## Zoning Review –midtown Building 2

## Building Elevations – Design Review under the B-7 Design Guidelines

The Building 2 Exterior Elevations, Sheets A-3.1 and A-3.2 prepared by THA Architects, LLC with an issued date of Feb 8, 2016 and a revision date of March 14, 2018, meet the design standard with the Planning Board's condition of approval, which is noted on each sheet, and is stated below:

A-3.2

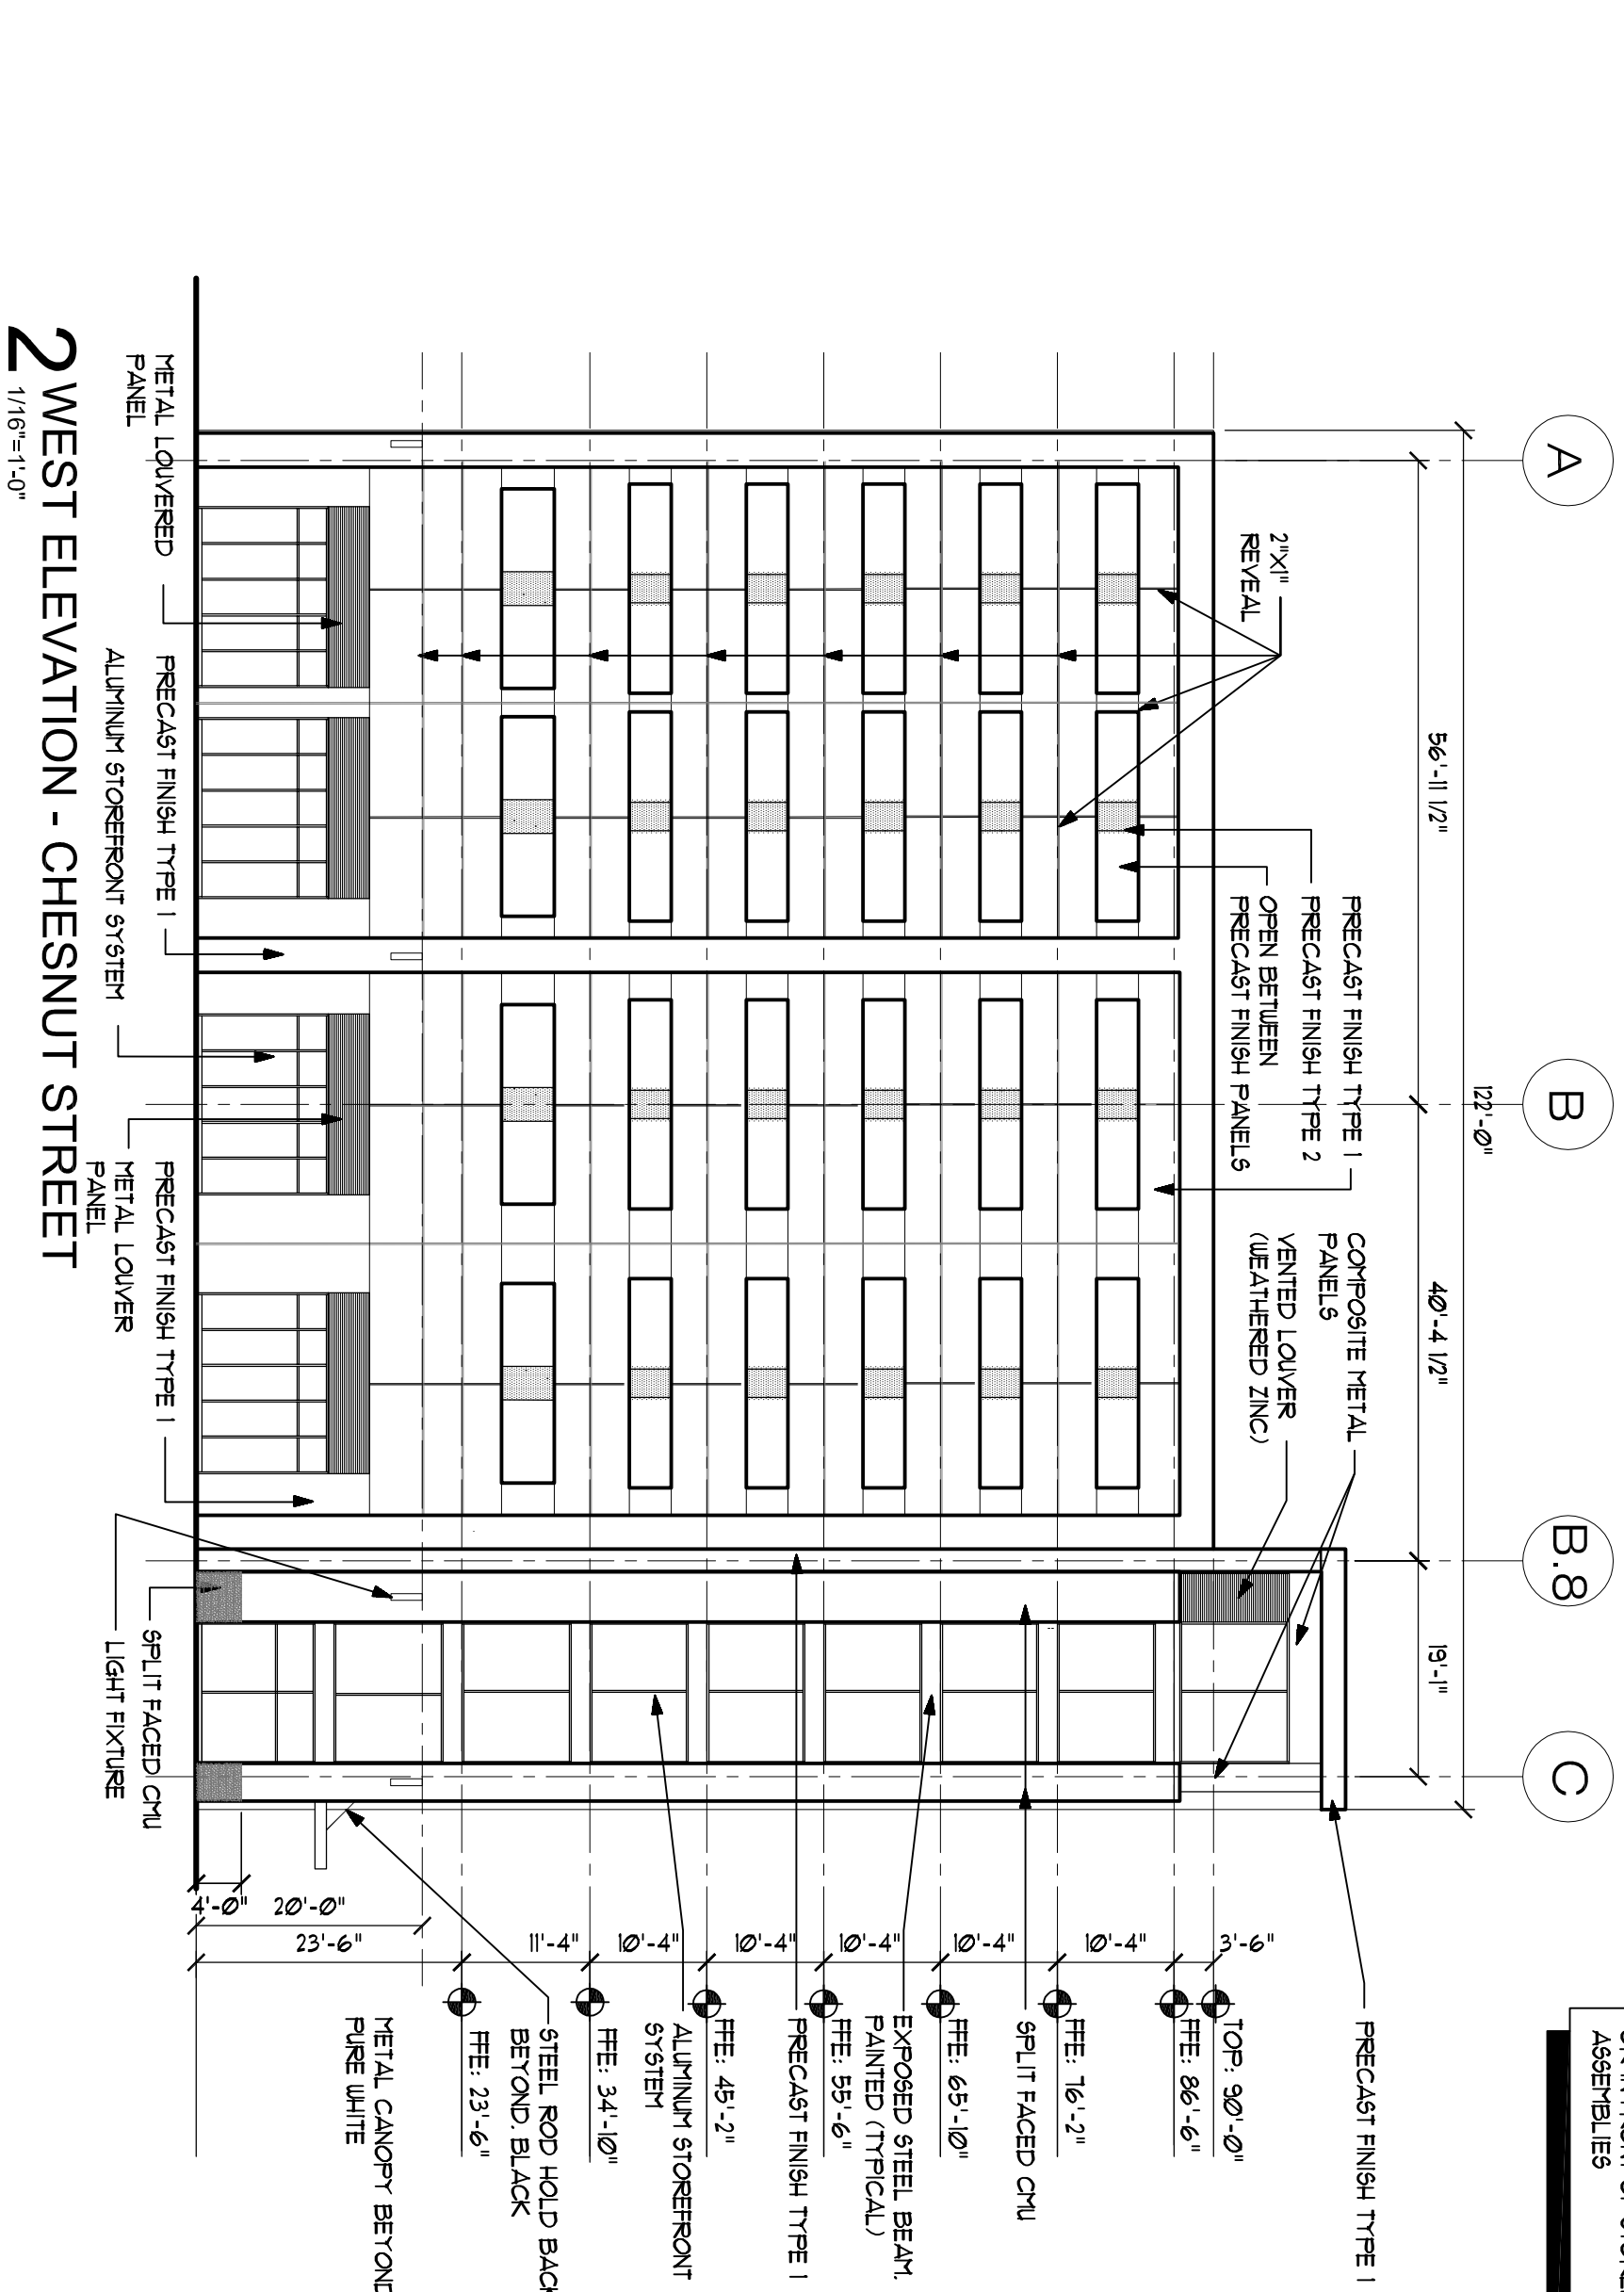
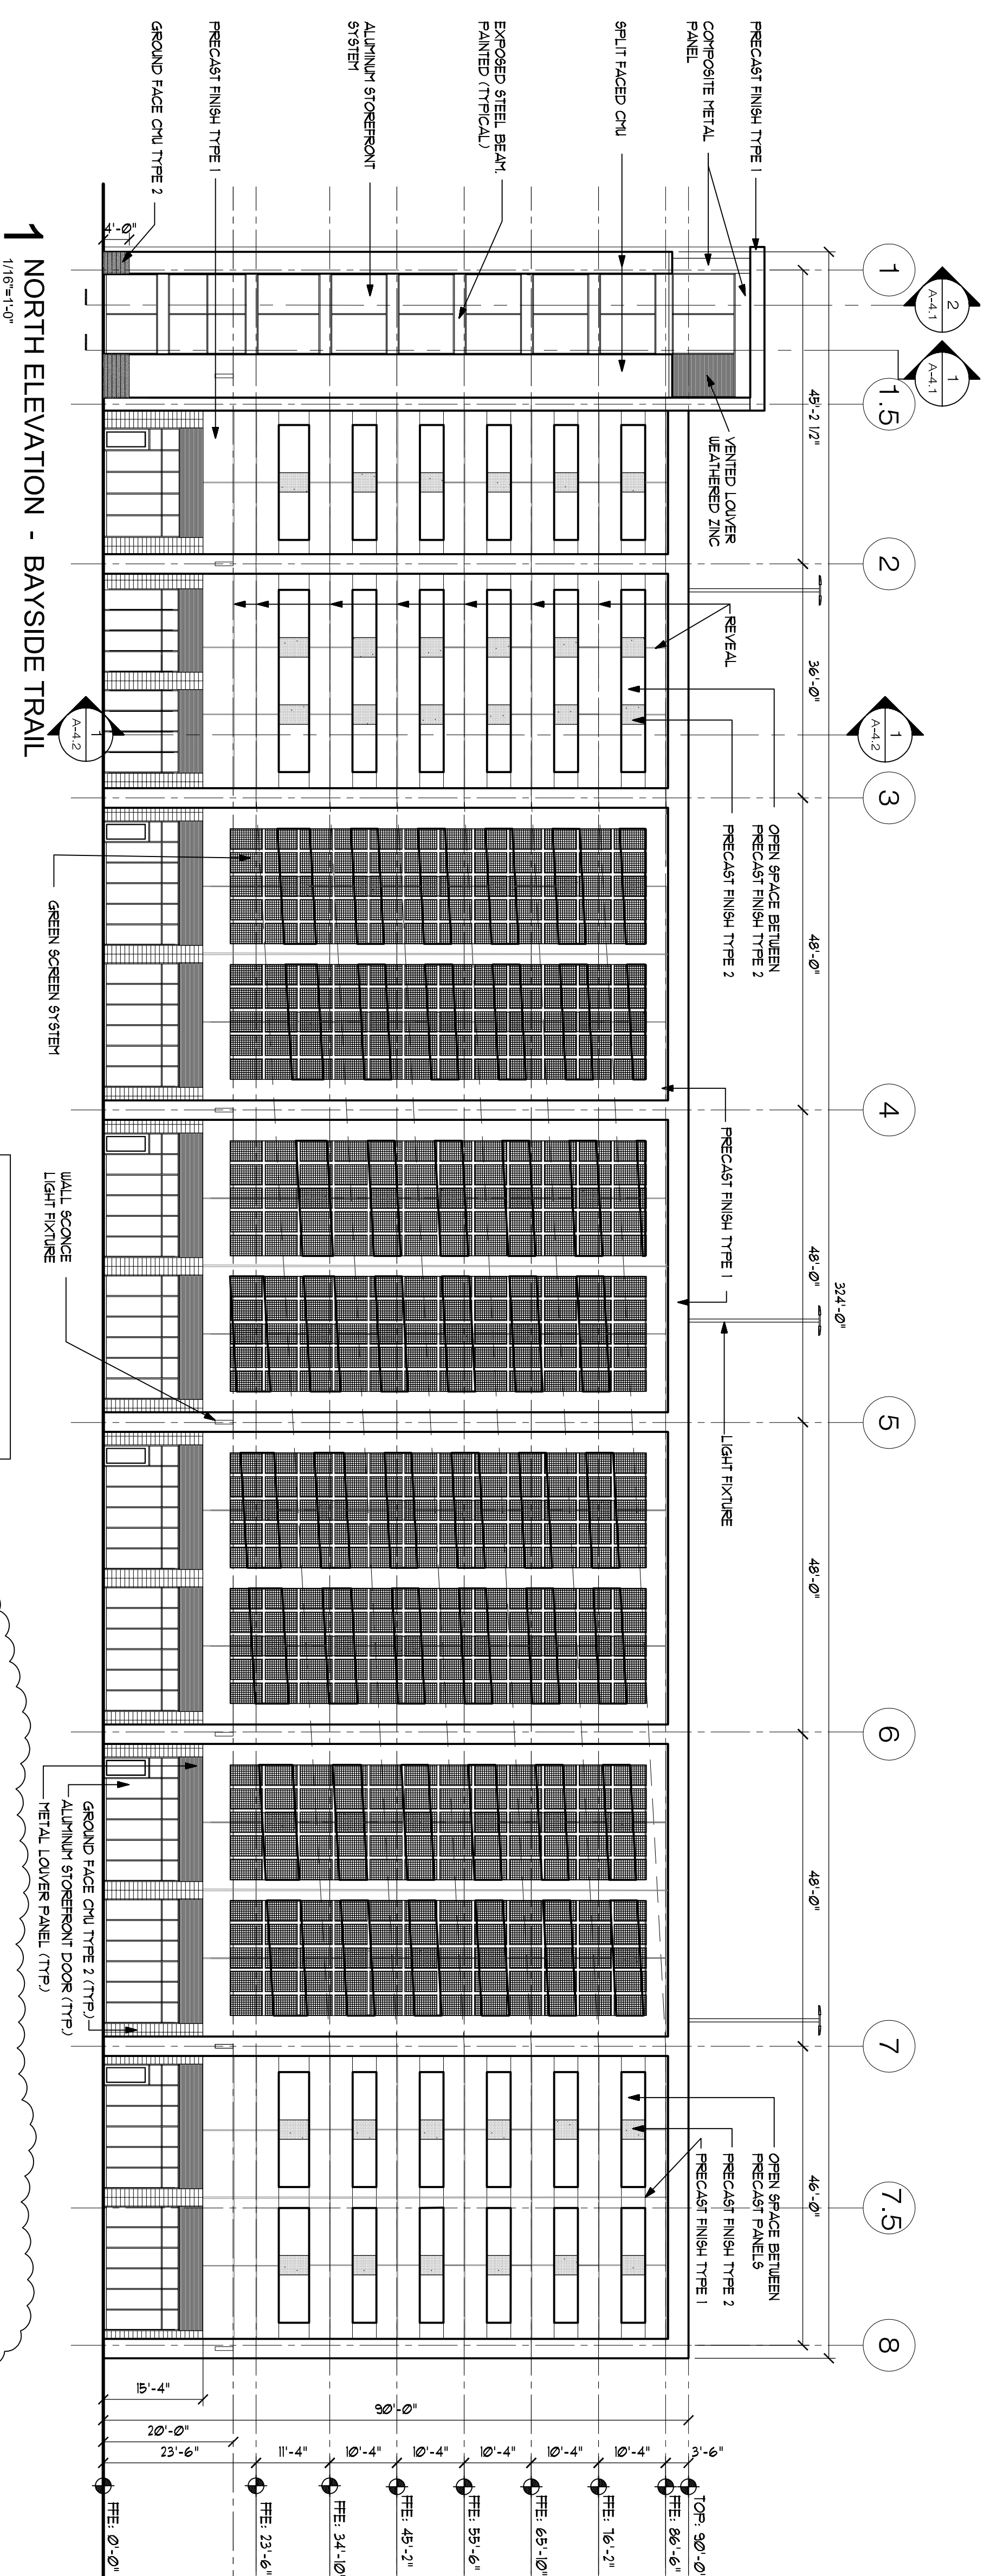
**Standard E-12: Materials: Final storefront design shall be subject to approval of the Planning Authority and, as the rest of the ground level, be completed in materials on the "predominant materials" list in Standard E-12.**

**Please note to Permitting and Inspections: Any revisions to the exterior storefront design must be reviewed by the Planning Authority.**

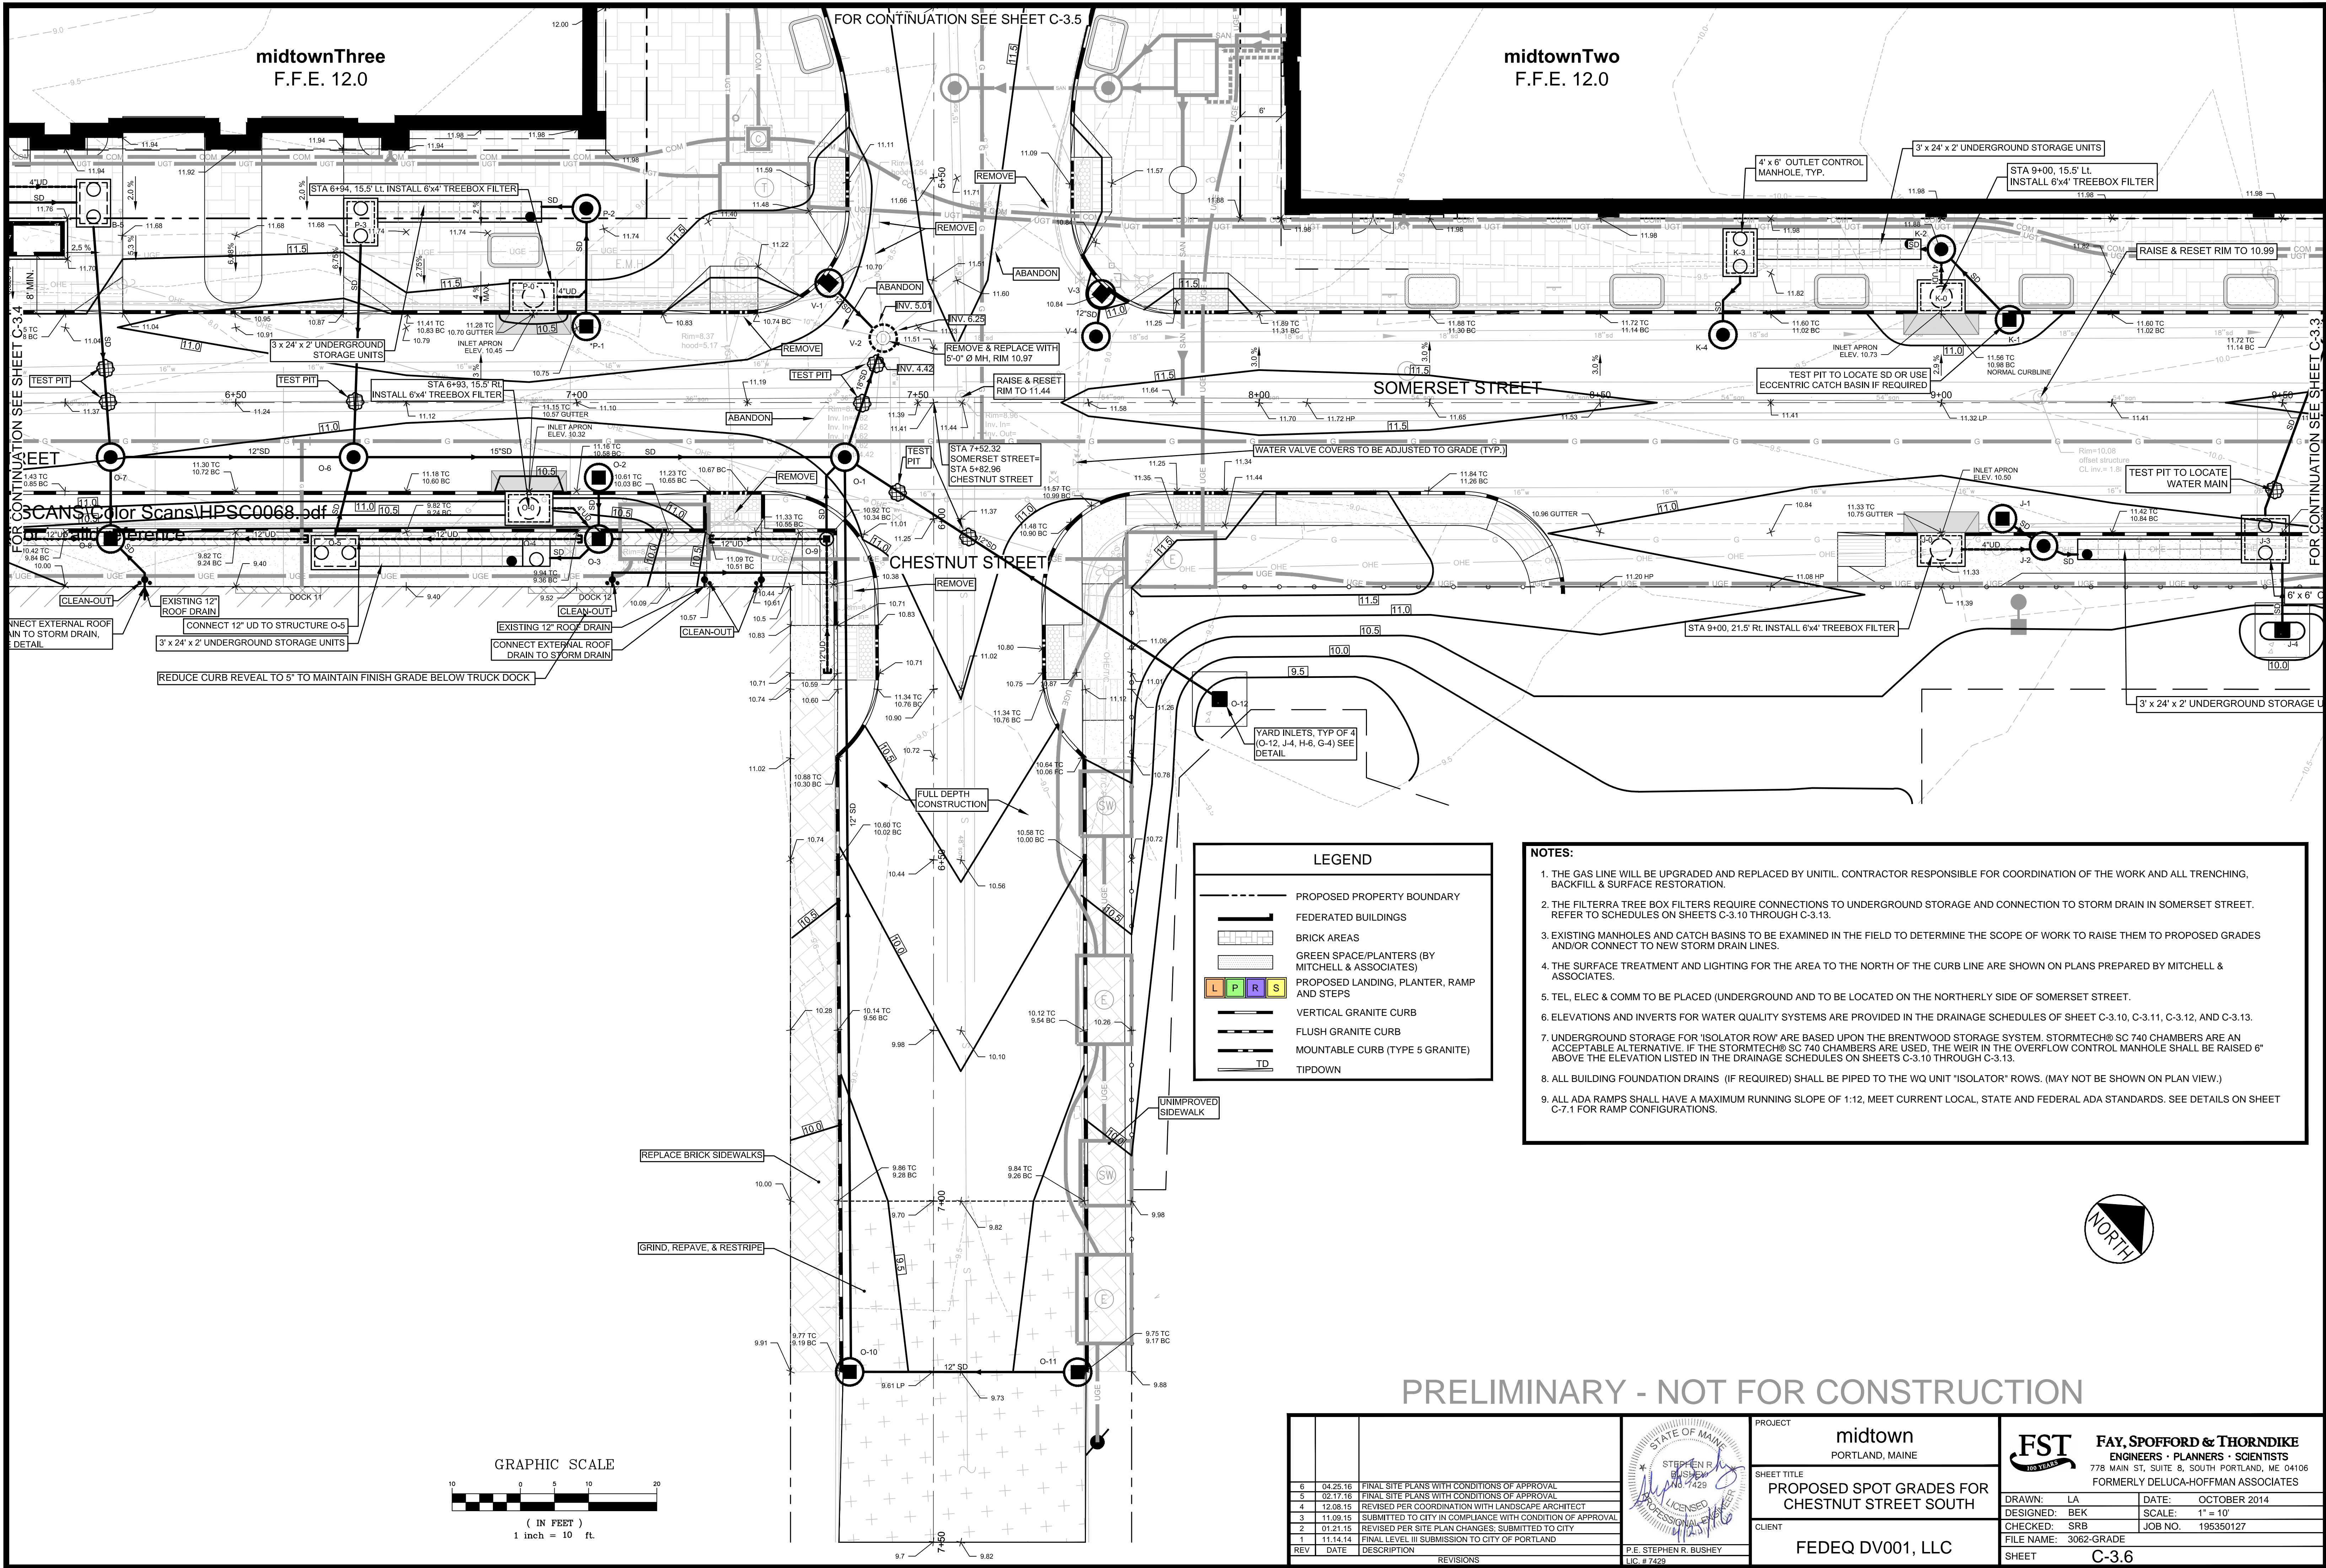
***Civil sheet C-3.0 shows the building's BFE at 12'. There is no meaningful step down (or up) from the building to the grade at any corner.***

***The following sheets confirm this (to within a negligible measurement).***
